From: [REDACTED]
To: [Planning](#)
Subject: 6/2016/0038/HOUSE
Date: 24 March 2016 17:02:23

6B HILL RISE, CUFFLEY

Further comments re above:-

DRAWING TITLE  
 Garage  
 Floorplans & Elevations

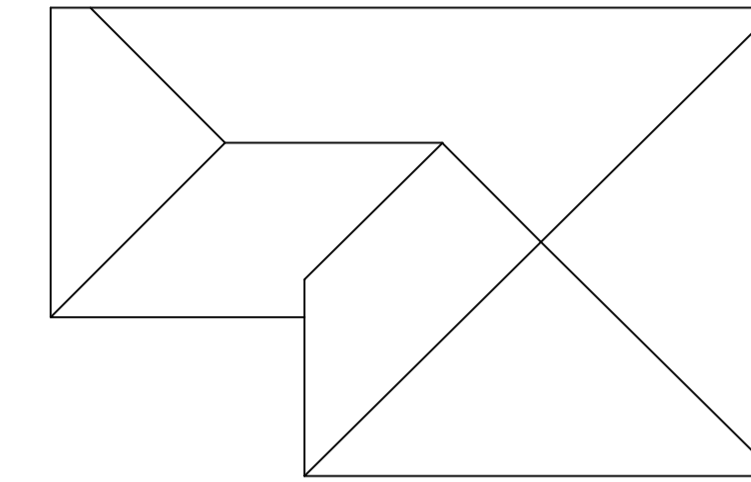
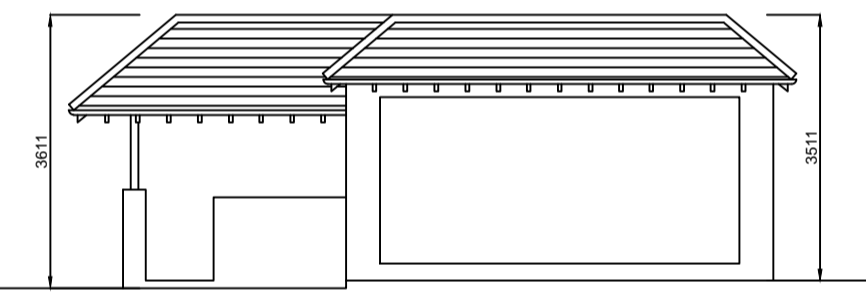
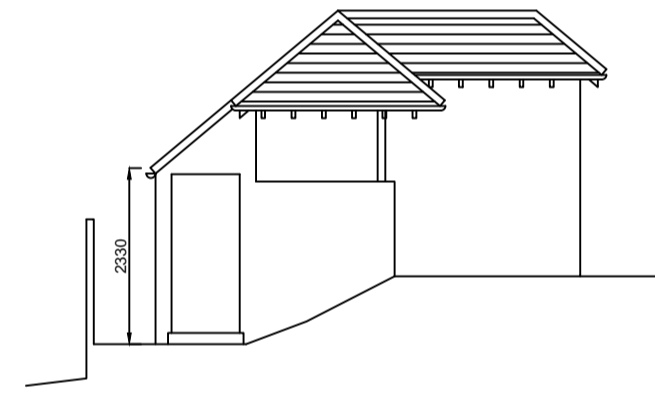
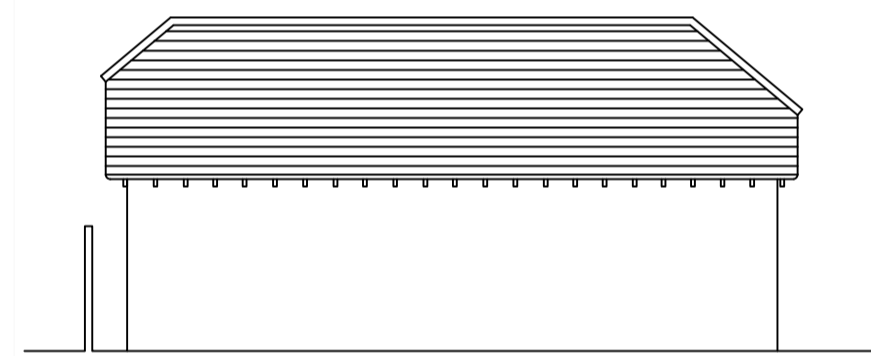
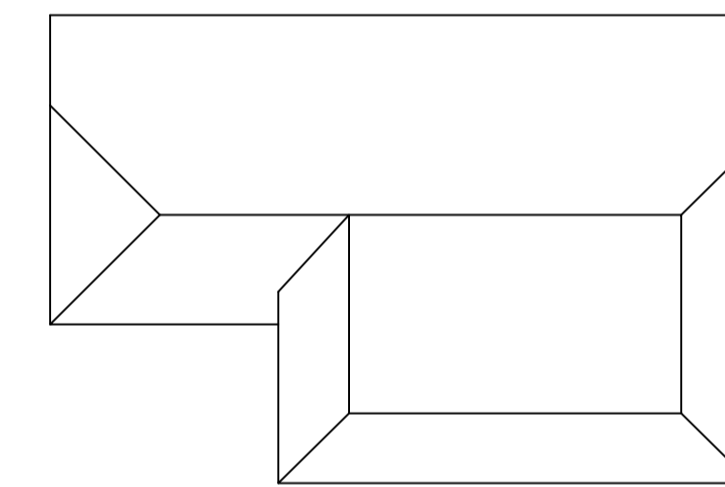
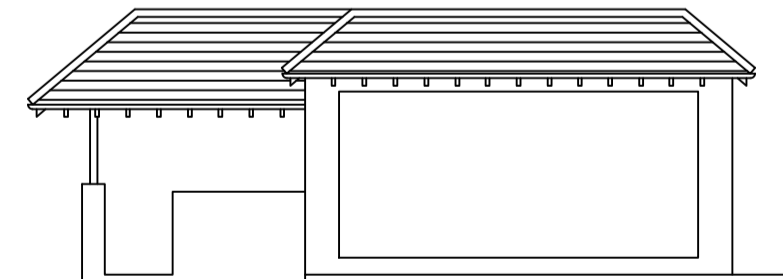
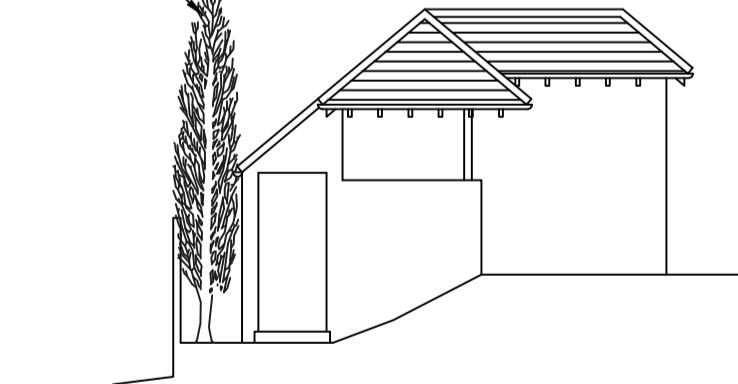
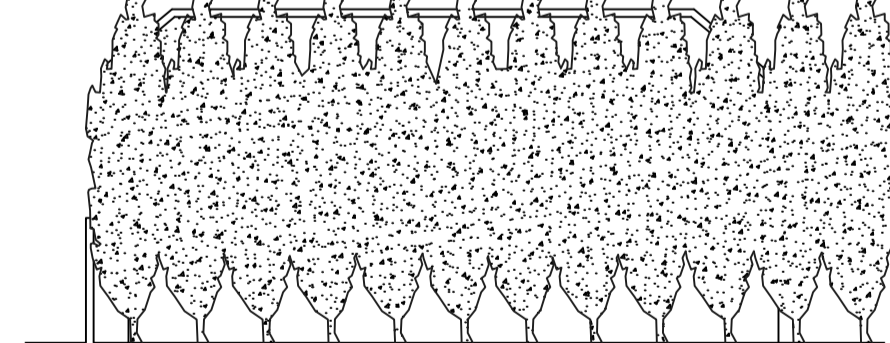
The Parish Council's preference is for the previous proposal. In our view, the building height is out of character and overbearing on neighbouring properties.
